24/21/A/PL

Application for removal or variation of a condition following grant of planning permission.

DEVELOPMENT: LUV TREATMENT BUILDING AND ASSOCIATED UPGRADE FACILITIES
(EG/22/15/PL - 20TH MARCH 2015)

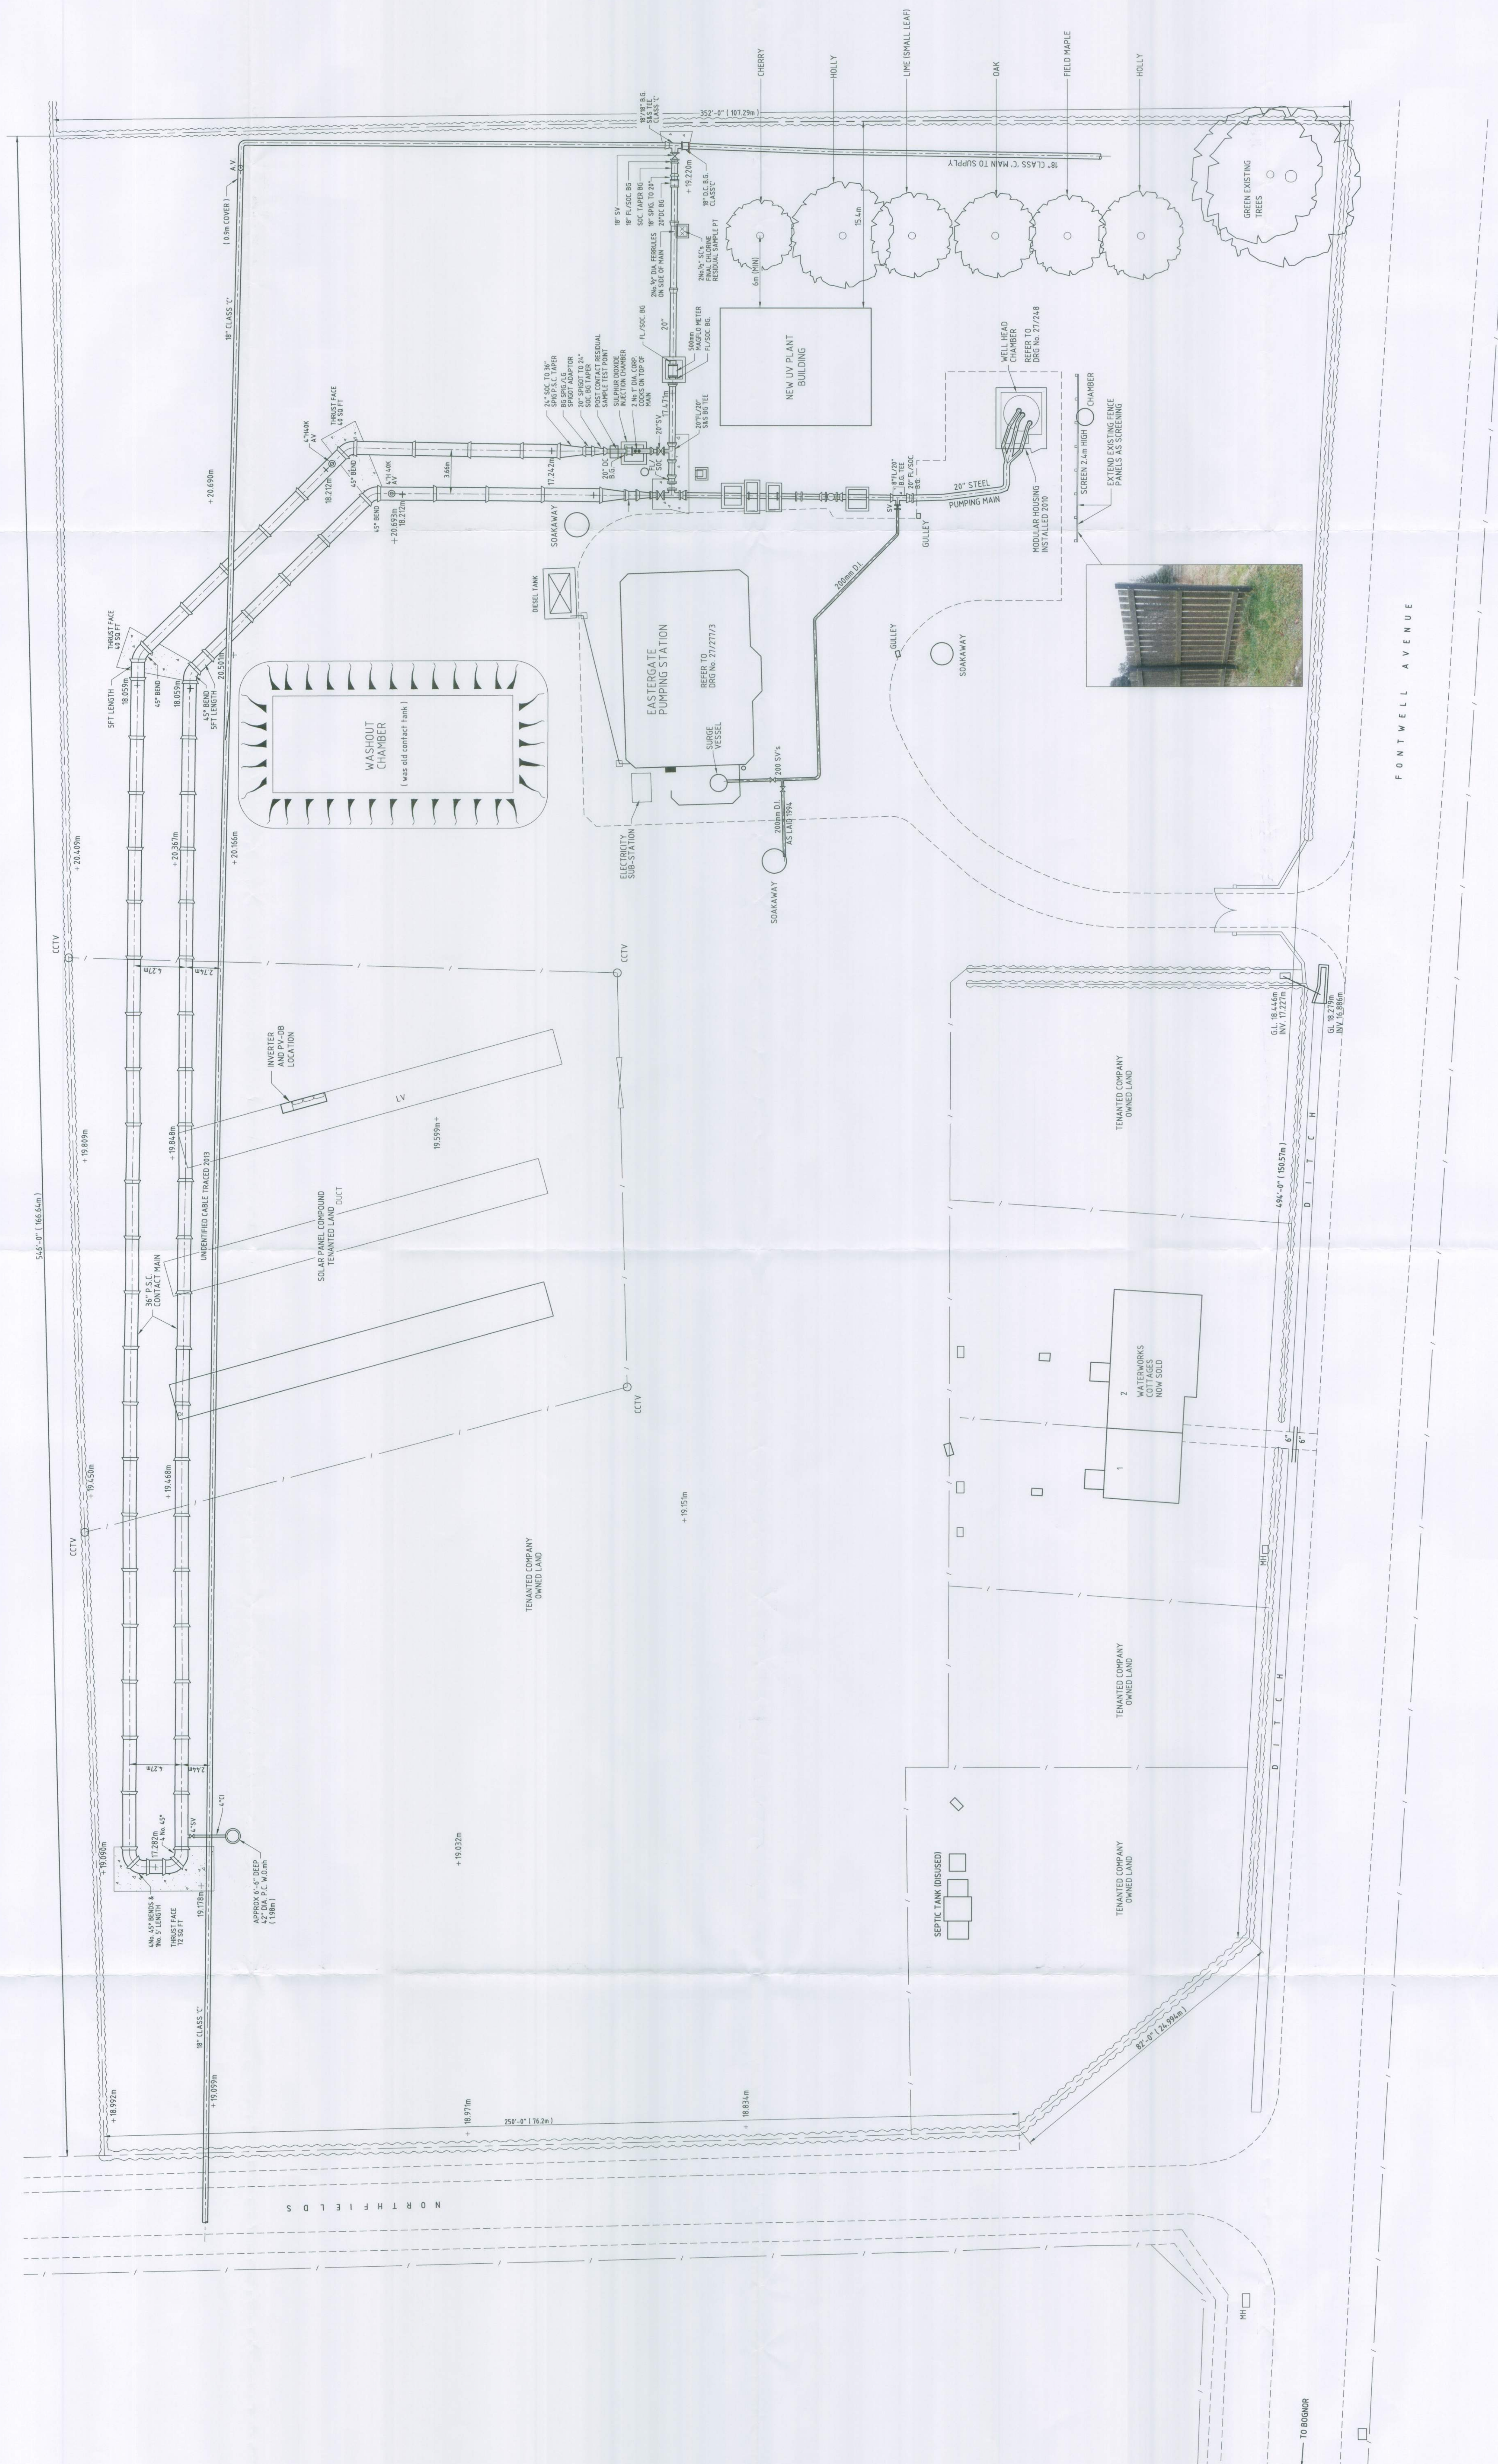
COLOURS SHOWN ON DRAWING 27-5132600-031 REVAL ARE INCORRECT. WE WISH TO CHANGE THE COLOURS AS INDICATED BELOW. ROAD LAYOUT HAS BEEN ALTERED. NEW LANDSCAPE & DRAINAGE DETAILS TO REFLECT SITE REQUIREMENTS
